REPORT UPDATE

Application No: FG/85/15/PL

PROPOSAL: Demolition of three buildings & erection of replacement workshop & machinery store (amendment to FG/161/14/PL).

Project ADC/5/14	Sheet 4Fii
Date 15.07.2015	
Scale 1:100 @ A1

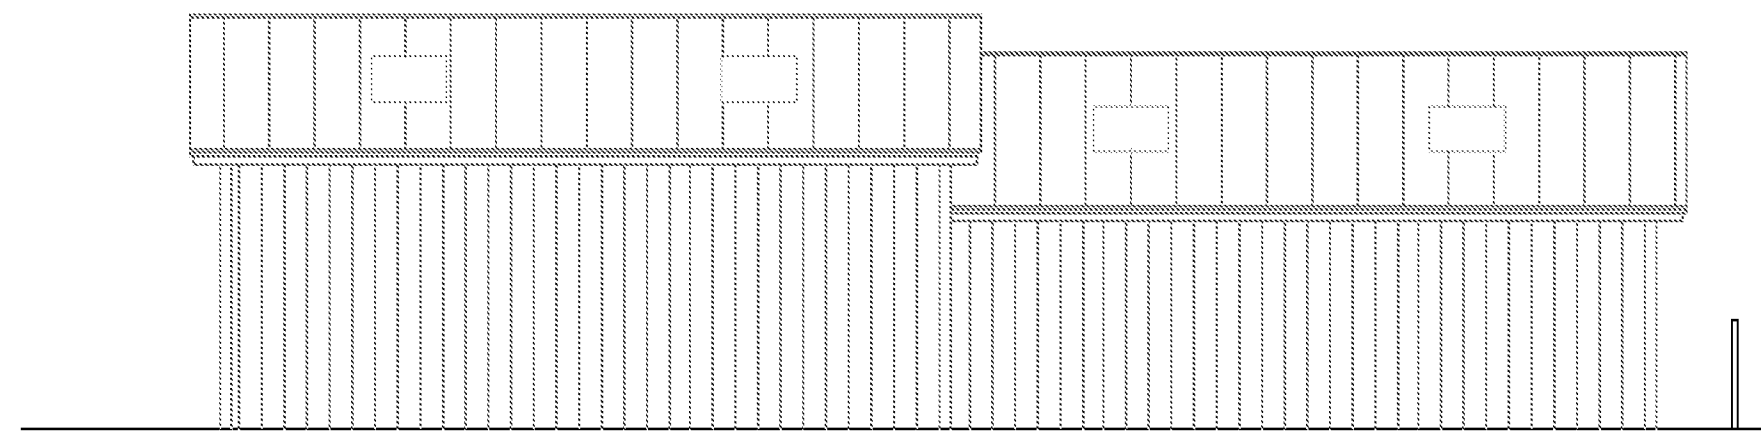
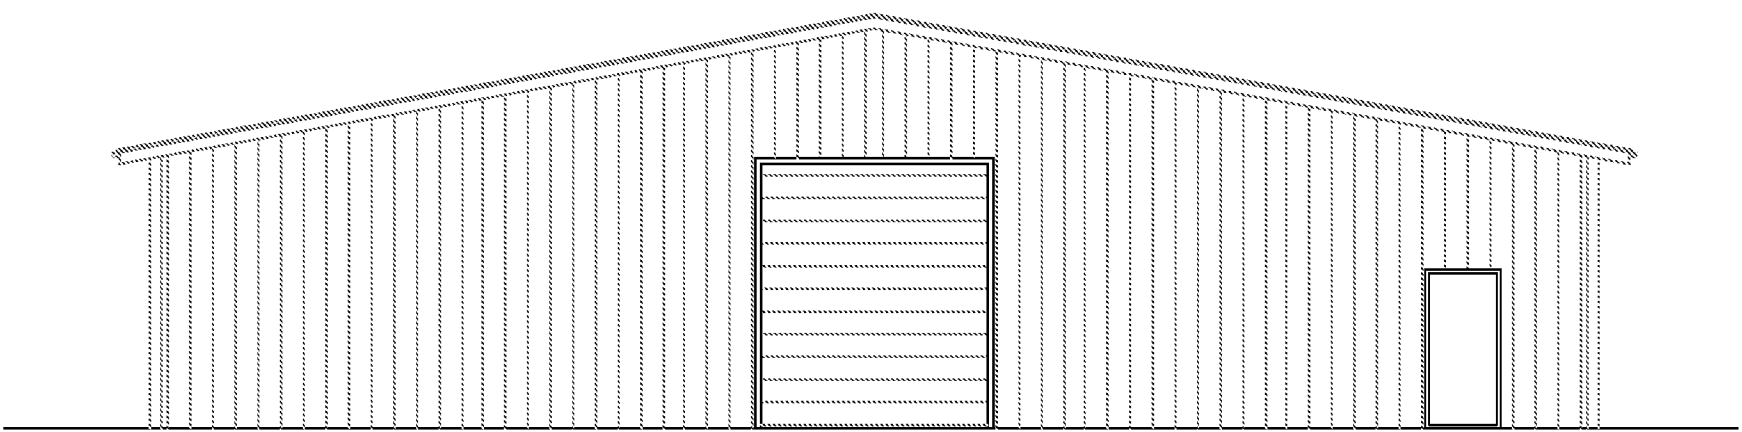
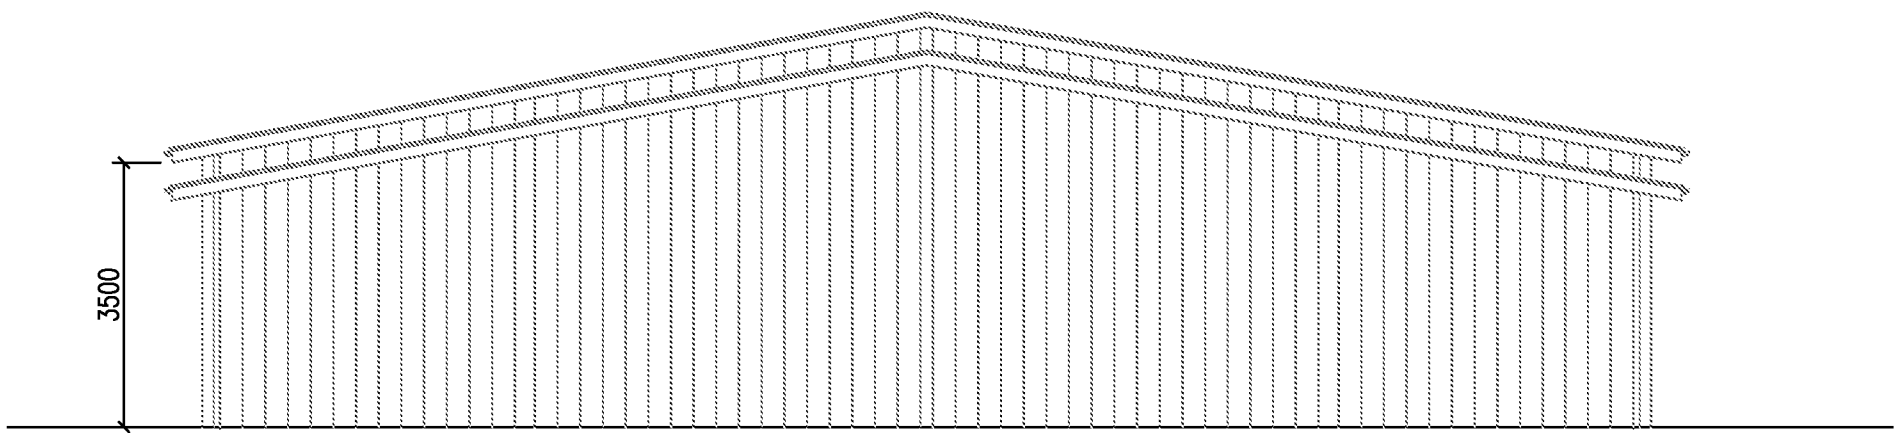
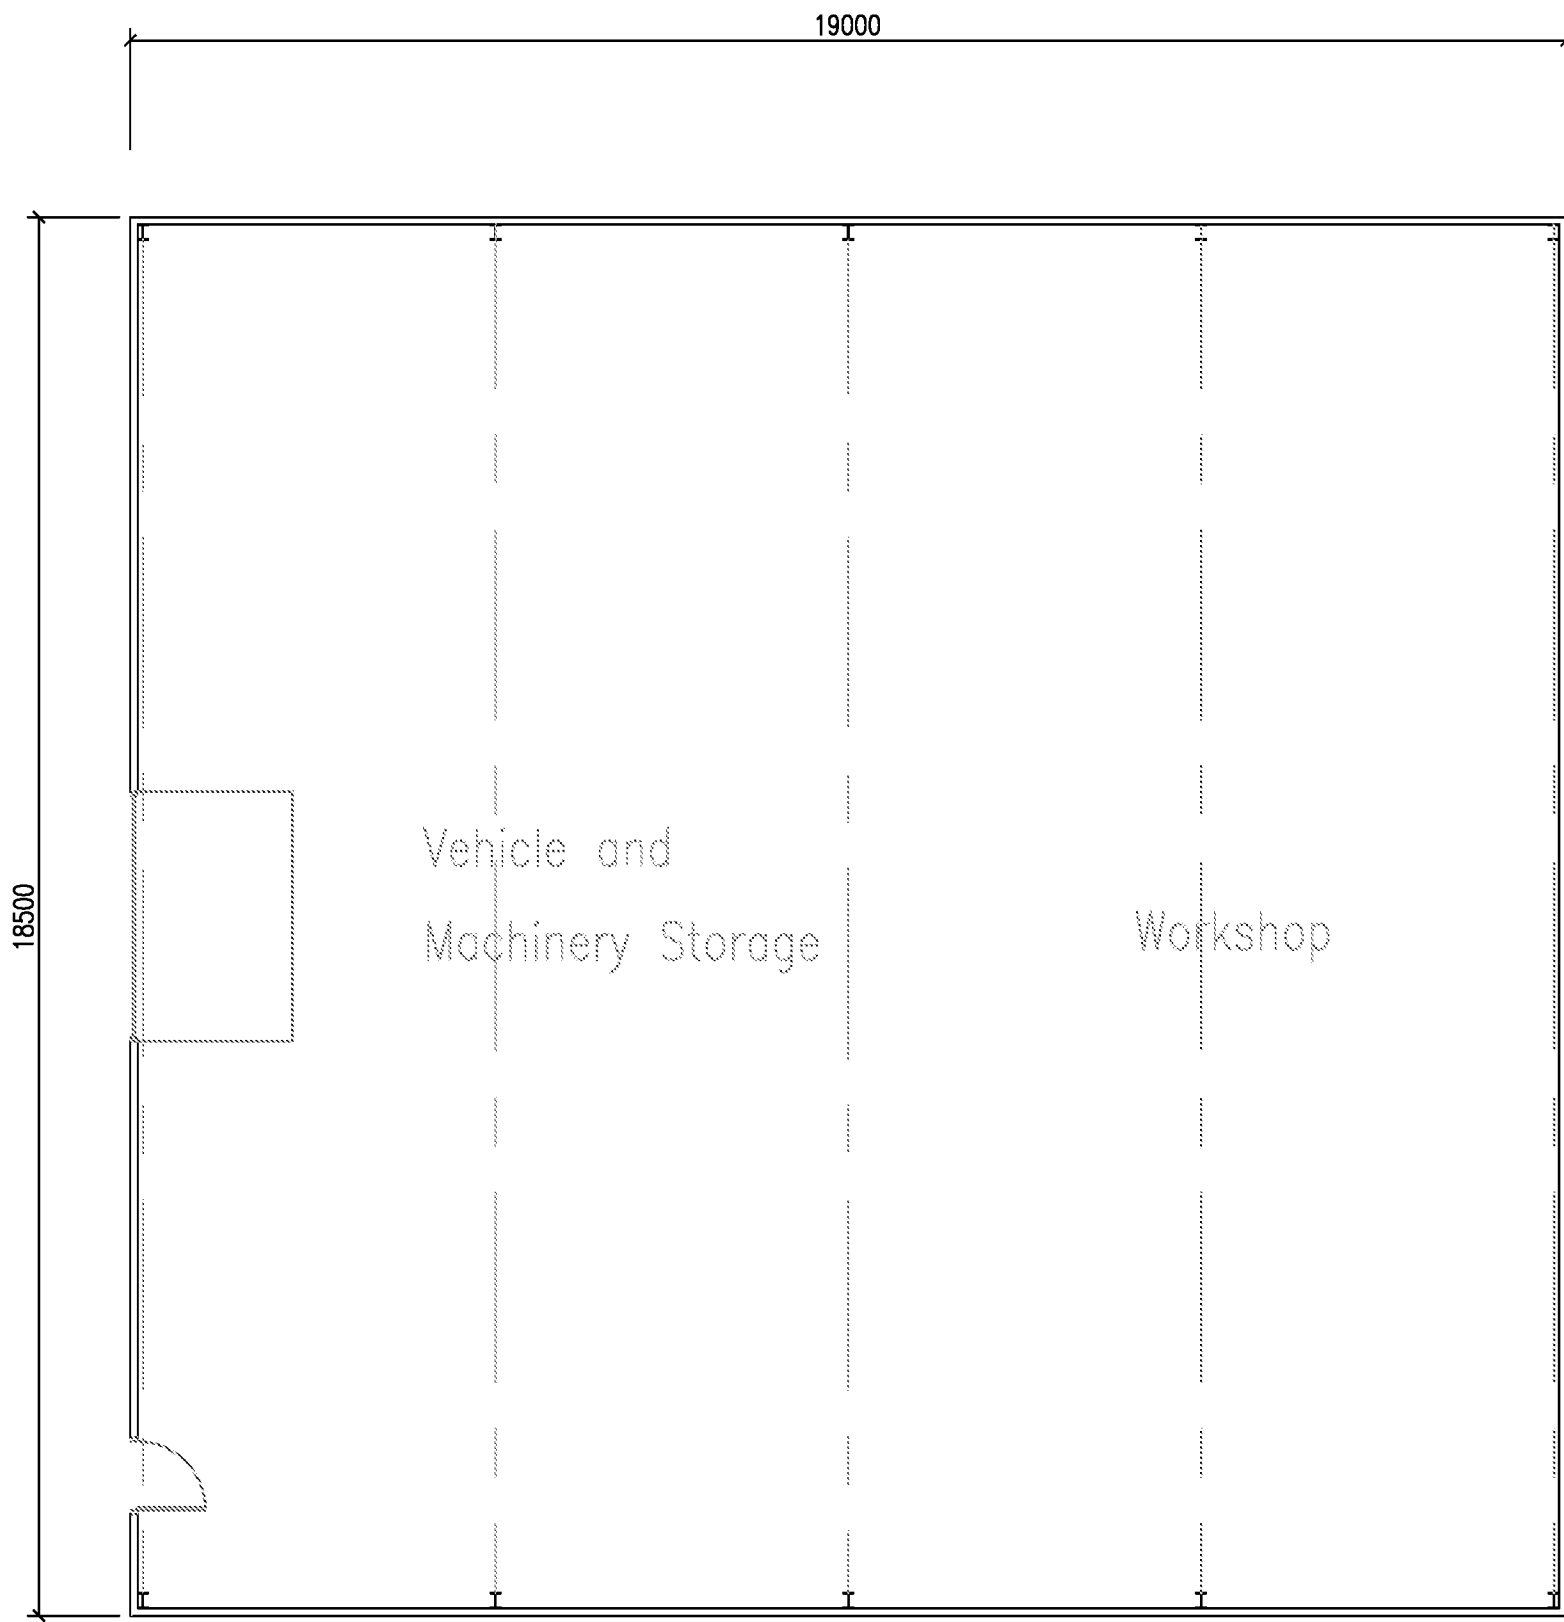
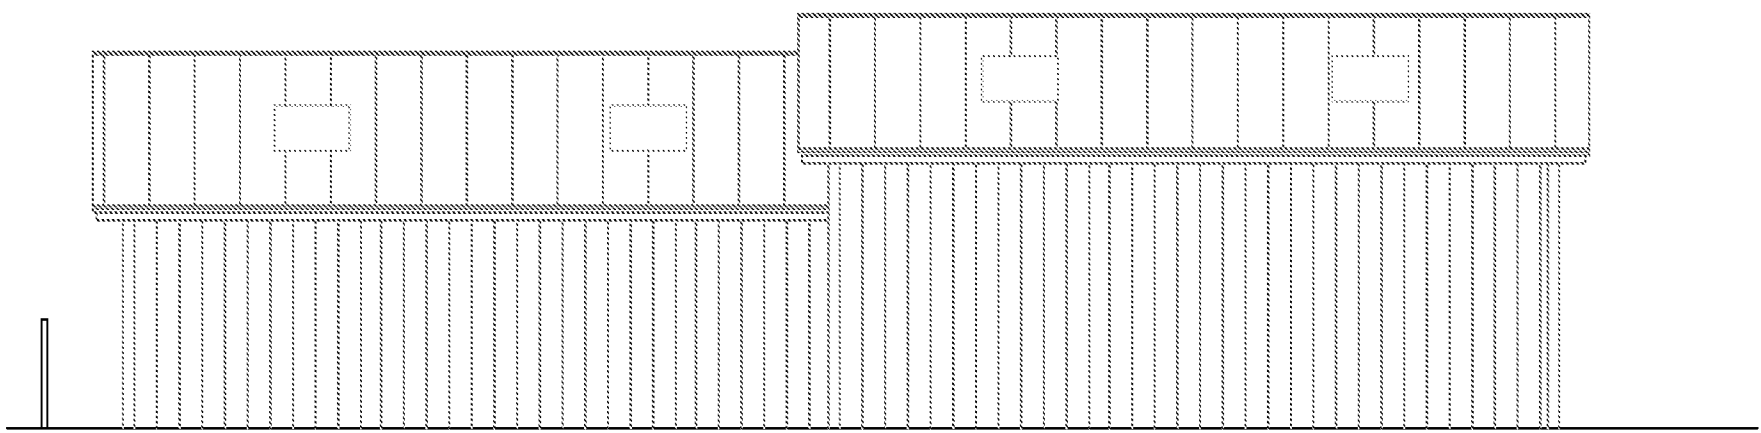
The agent has submitted substitute plans showing an increase in the lower roof section of the building which reduces its overall size and bulk.

The application has been amended since originally submitted to reduce the width of the proposal by 1.5m and the overall floor area by 30m². It is considered that the building size has been appropriately minimised to limit its visual impact and the floor area proposed has been satisfactorily justified. The building is necessary to store and maintain equipment required to meet the day to day needs of the business. The offset position adjacent to the access road and site entrance is considered appropriate.

Accordingly the wording of the plans condition has been amended

- 2 The development hereby approved shall be carried out in accordance with the following approved plans Sheet 1 Location Plan, Proposed Block Plan 2Fii, Floor Plan and Elevations 4Fii.
